TfNSW Reference: SYD20/00390/05

Client Reference: SSD-10446

RESPONSE TO SUBMISSIONS FOR LUDDENHAM CLAY/SHALE QUARRY TRANSPORT OPTIONS - 275 ADAMS ROAD, LUDDENHAM

**ROADWORKS PLAN**  
SCALE 1:250

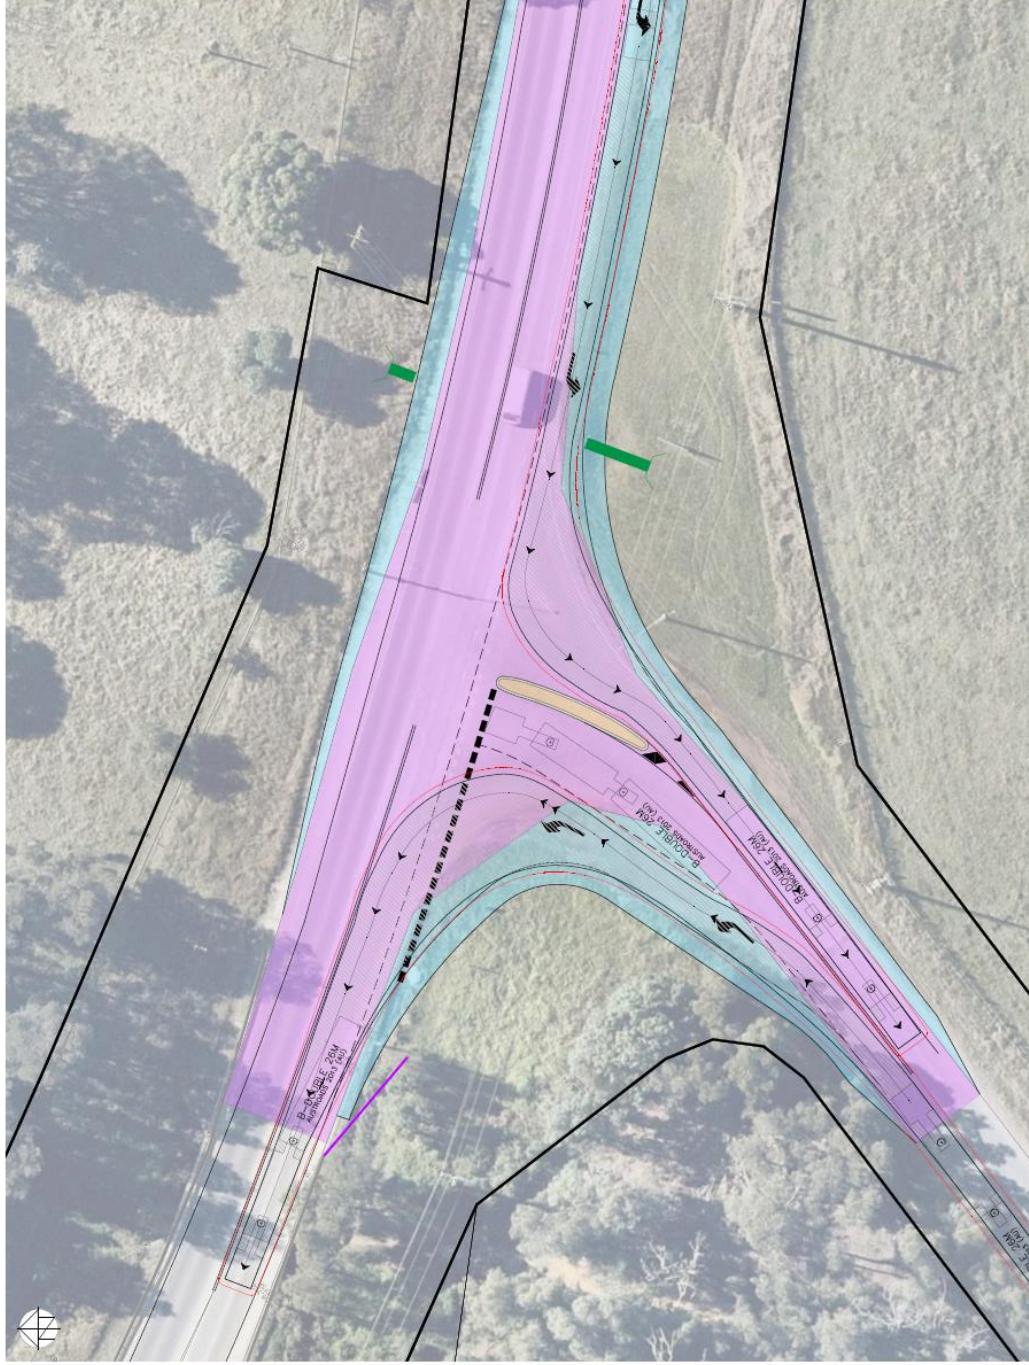
2. TfNSW understands that the proposed 90m long deceleration lane in the interim upgrade of Elizabeth Drive and Adams Road intersection is based on the requirements set out in Austroads for a design speed of 90 km/h with the deceleration rate of 3.5 m/s to a stop condition. As the left turn lane will mainly accommodate heavy vehicles, such as 26m B-Doubles, a deceleration rate of 2.5 m/s should be used with a turning speed of 20 km/h. This will require 120 metres including taper for the deceleration lane for the left turn movement.

As such, the concept design plan should be updated to address the above issue with showing the dimensions and submitted to TfNSW for review and approval.

- Left turning pavement arrow spacing distance should be in accordance with AS 1742.
- The Give-way signage and linemarking should be demarcated according to TfNSW's Delineation manual Section 6 – Transverse markings. The TB and TB1 linemarking should be provided as per page 7 on the following link: https://roads-waterways.transport.nsw.gov.au/business-industry/partners-suppliers/documents/technical-manuals/delineation/delineationsect6v12_i.pdf

- C1 linemarking should be provided between lane one and two on Adams Road.
- The raised concrete median should be installed at Adams Road to enhance the safe turning path of heavy vehicles at the intersection subject to Council's satisfaction.

- A 'Keep left' R2-3_L signage should be provided on the central median, on Adams Road, facing north.
- T1 linemarking between the left turning bay and through lane on Elizabeth Drive should be changed to C1.

- A 2.0m sealed shoulder should be provided to the deceleration lane and the departure kerb return from Adams Road.
- It is noted that the existing safety barrier along westbound Elizabeth Drive will be impacted by the proposed intersection upgrade. Measures should be provided to mitigate this impact.

- The concept design plan should identify the utility infrastructure to be impacted by the intersection upgrade and the relocation of these impacted infrastructures.
